Morgan and Morecambe Offshore Wind Farm: Transmission Assets

**Appendix G5.3 to Natural England's Deadline 5 Submission
Natural England's comments on Outline Landfall Construction Method Statement [AS-
081]**

Planning Inspectorate Reference EN020028

22 September 2025

Figure 1 Intertidal and Landfall Works Areas

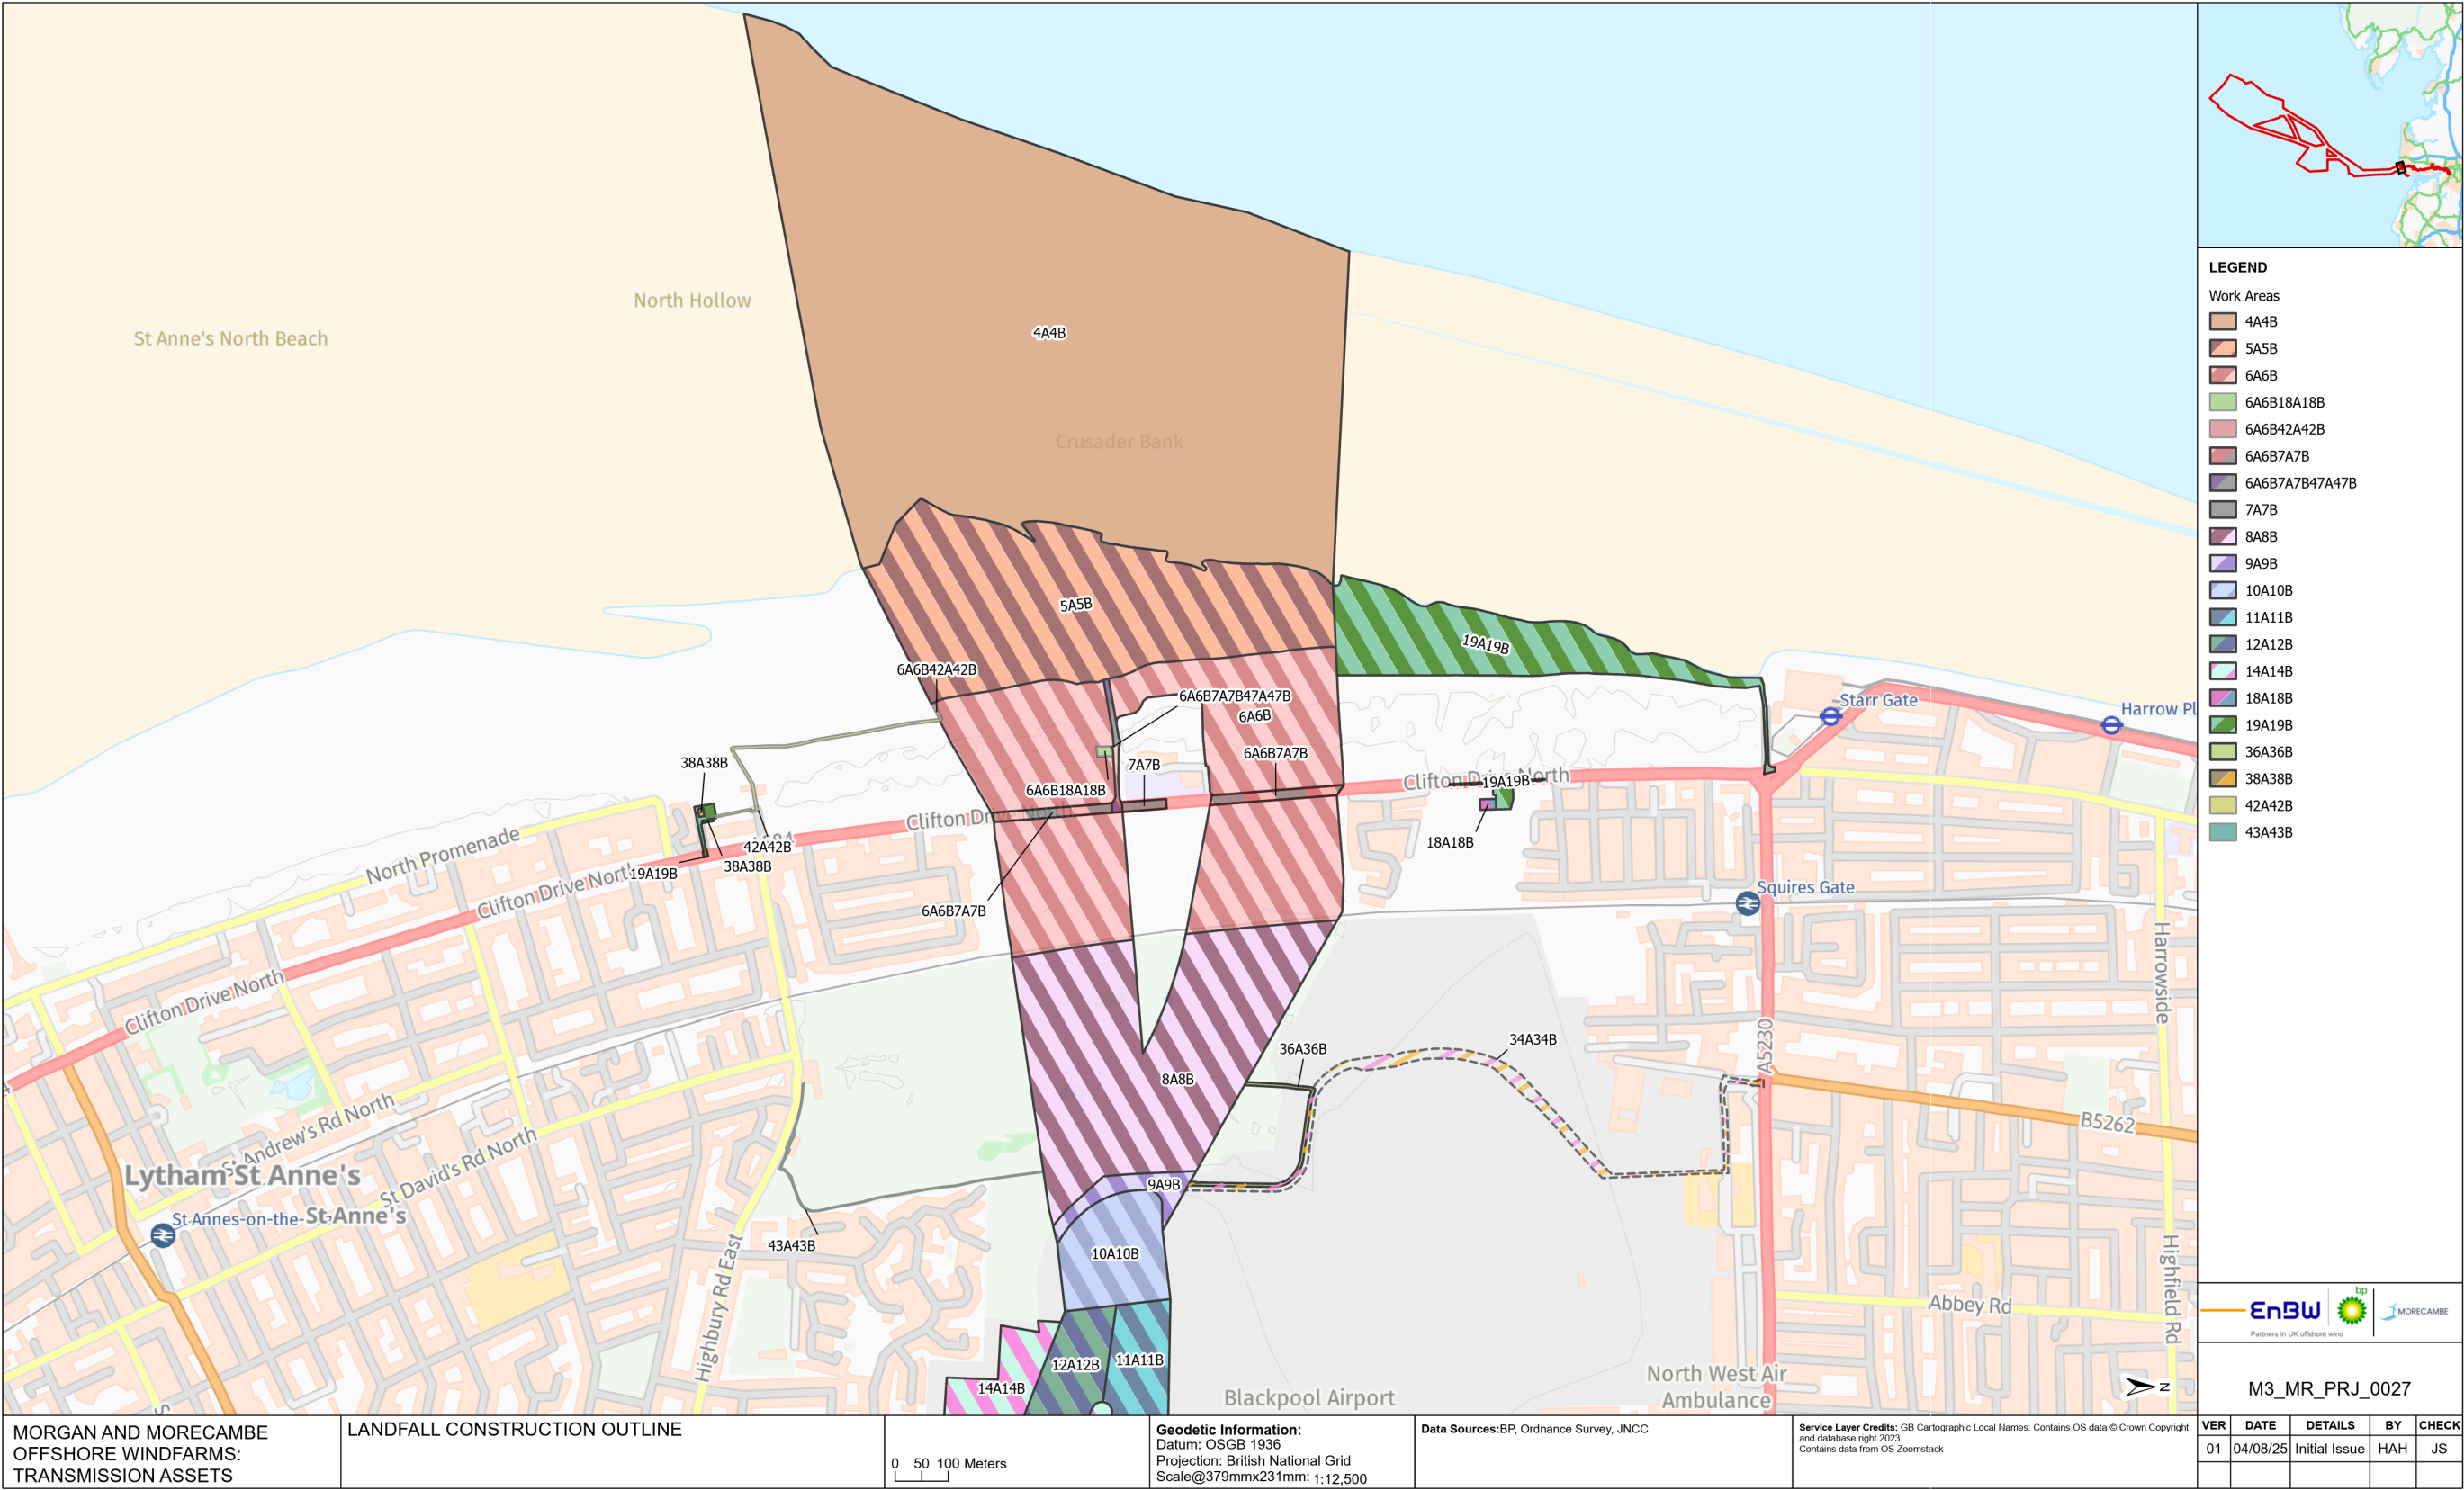
4	Table 1, CoT85	<p>Natural England notes the commitment which includes the temporary haul roads will be installed using meable gravel aggregate.</p> <p>The track (42A42B) shown in Figure 1 and Figure 2 of the document runs along the outer edge of the accreting dunes - starting at the construction compound 1 and ending at construction compound 2.</p> <p>Paragraph 1.12.1.4 goes onto say that it will be a maximum of 6m wide but will not encroach onto the SSSI (which again should refer to <i>Lytham St Annes SSSI</i> as it does encroach onto the Ribble Estuary SSSI). The document here does note "<i>that removable track matting or similar membrane may also be required to transition from the track to the beach</i>".</p>	<p>From our experience on other projects where aggregate has spread across the designated site, we advise that further information/ detail on where the gravel aggregate will be used and an impact assessment is provided prior to consent to ensure that suitable mitigation measures can be adopted.</p> <p>If the gravel is intended to be used in the locations shown in the figures we advise that the use of gravel here is not appropriate as it could get intermixed with the sand and be difficult to remove at the end of works (i.e. as set out in CoT08) and an alternative trackway should be considered. This point is now included in the R&I Log (RI_G48).</p>
